**RE: Creekside PRD - Response to Technical Review #2
PA23-005**

Please refer to our responses below which address all review comments received from the City of Marysville dated 8/28 for planning, 9/25 for surface water, and 9/27 for traffic. Located at 7808 40th Street, 7811 & 7715 40th Street NE, APNs 29050200100200, 29050200100300, and 29050200100400. You will find the markup comments listed in the order that they were written followed by our response in *italics*.

**ROAD A AND B SECTION**  
SCALE: 1"=5'  
CITY OF MARYSVILLE STD PLAN 3-202-002

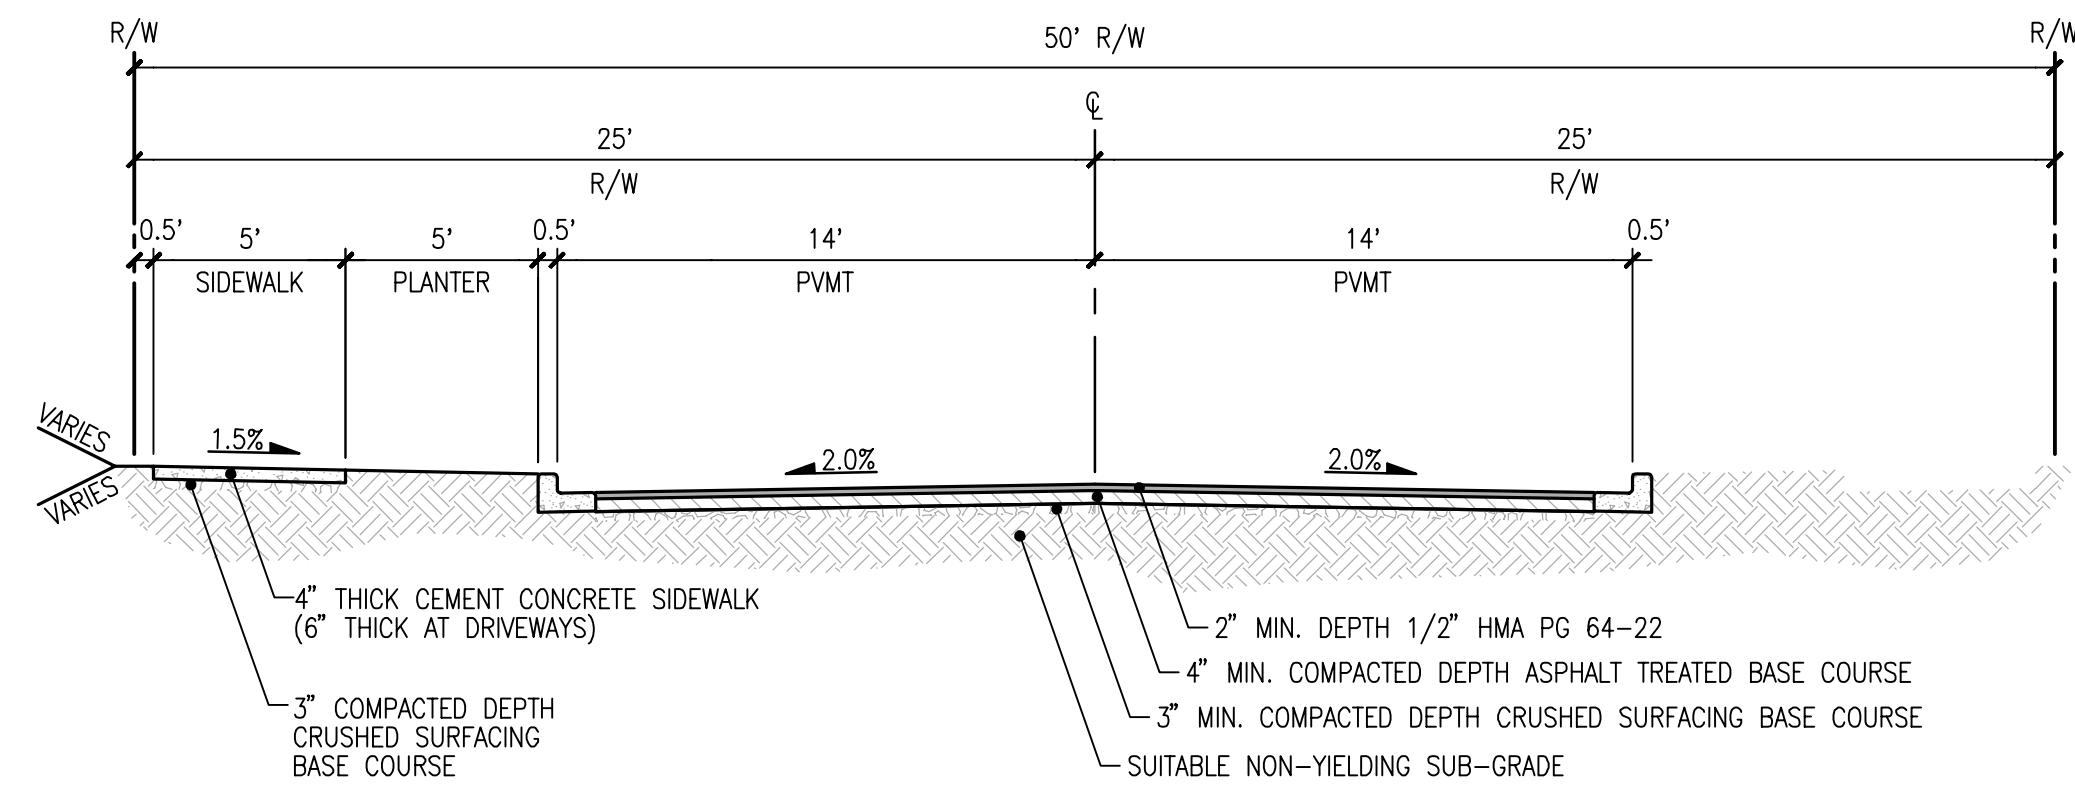
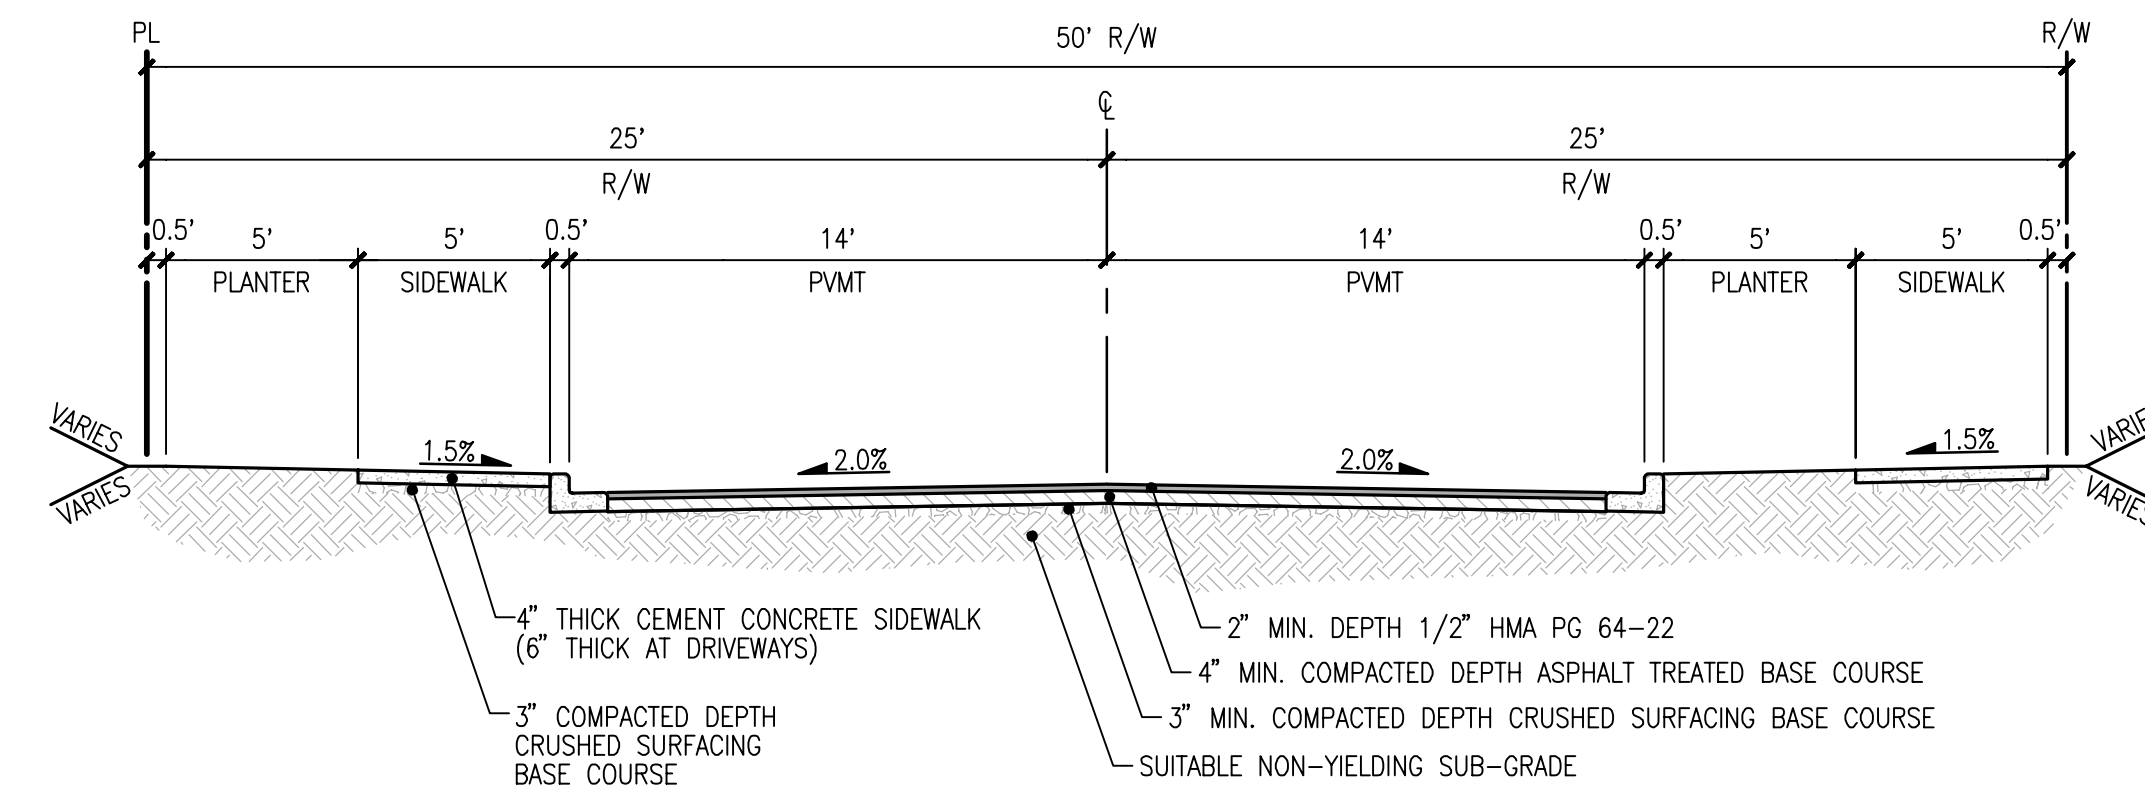
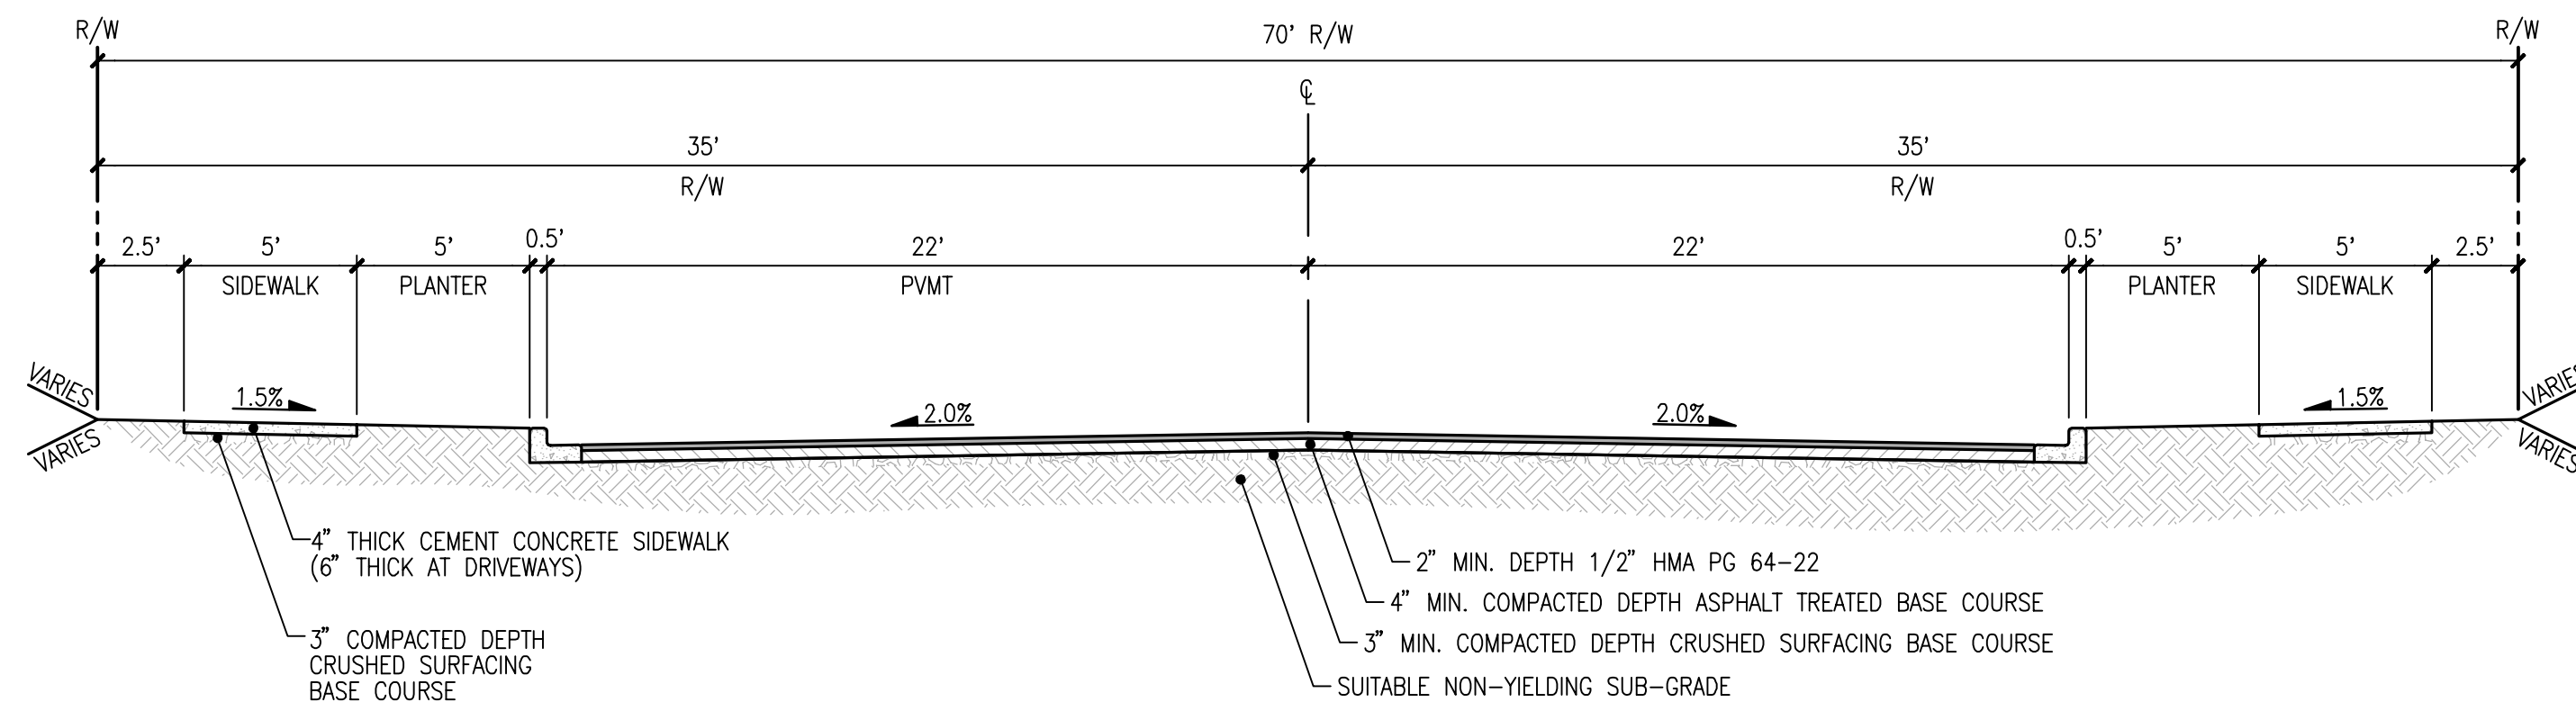
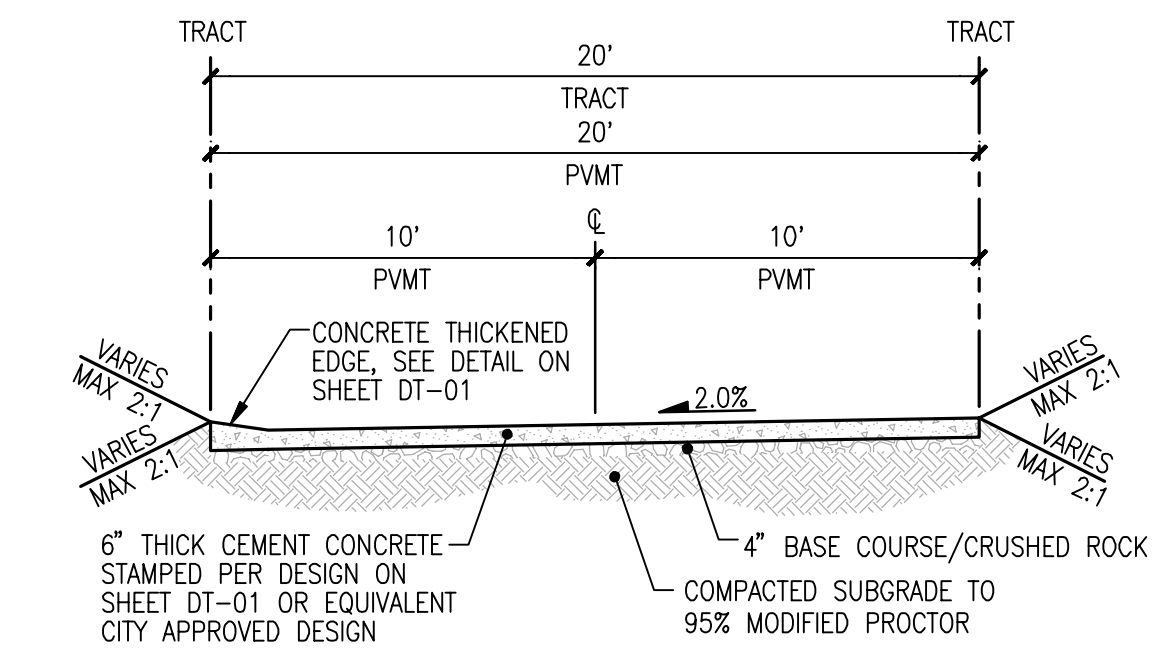
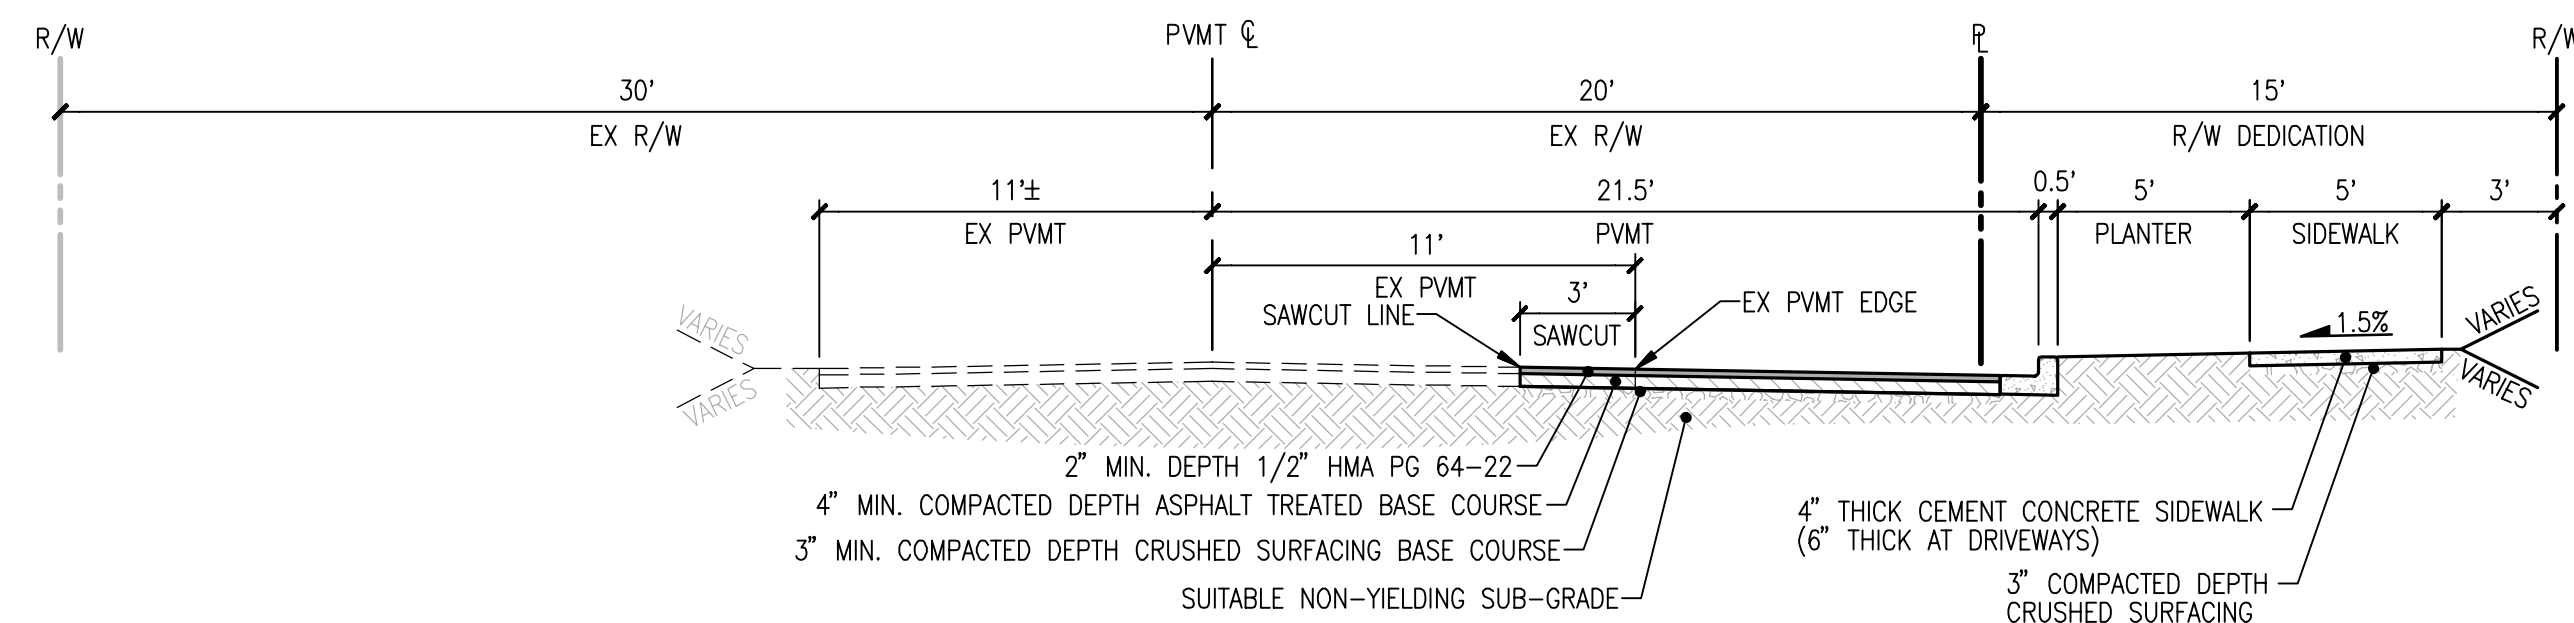
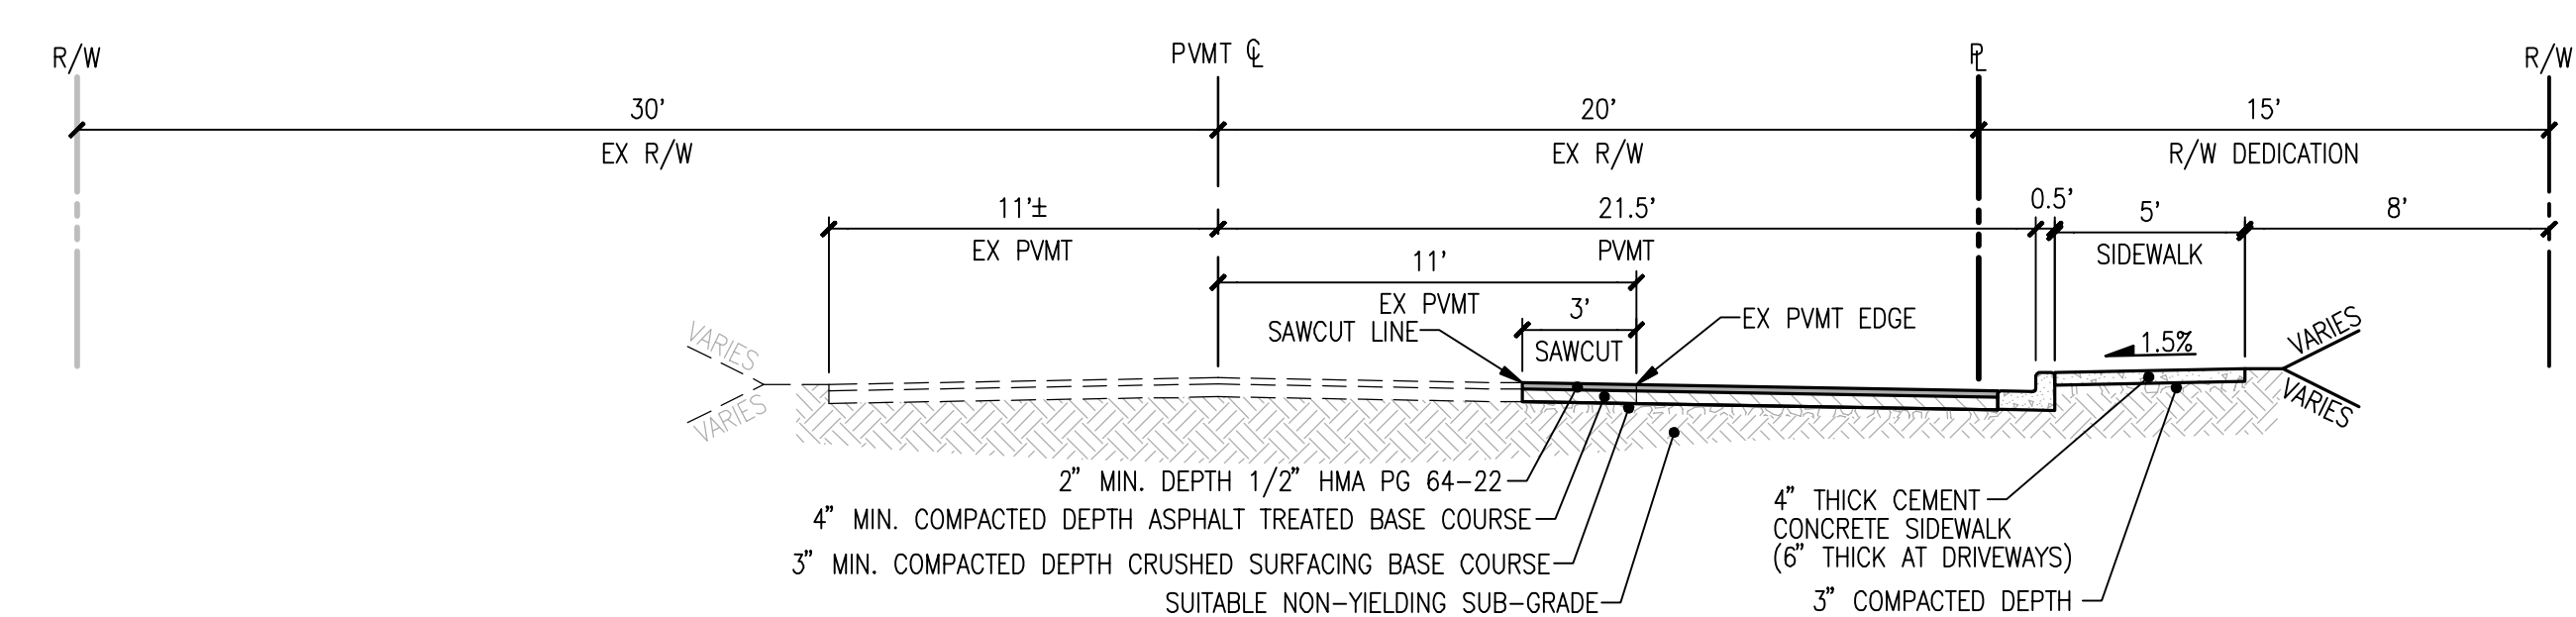
15. Frontage improvements shall be required upon 44th ST NE.
 - a. 44th ST NE is designated as a Collector Arterial.
 - b. Roadway cross-section shall be 70' ROW three lane roadway with bike lanes per EDDS Standard Plan 3-201-004

- iii. 40th ST NE shall be striped as permanent condition with bike lanes and two-way left turn lane including stop bar for EB approach to 79th Ave NE

Response: A dedicated 4' bike lane has been added to the cross section for 44th St NE.

Response: Proposed 40th St NE (Road C) now shows proposed striping on Section detail sheet RD-07 and in plan view.
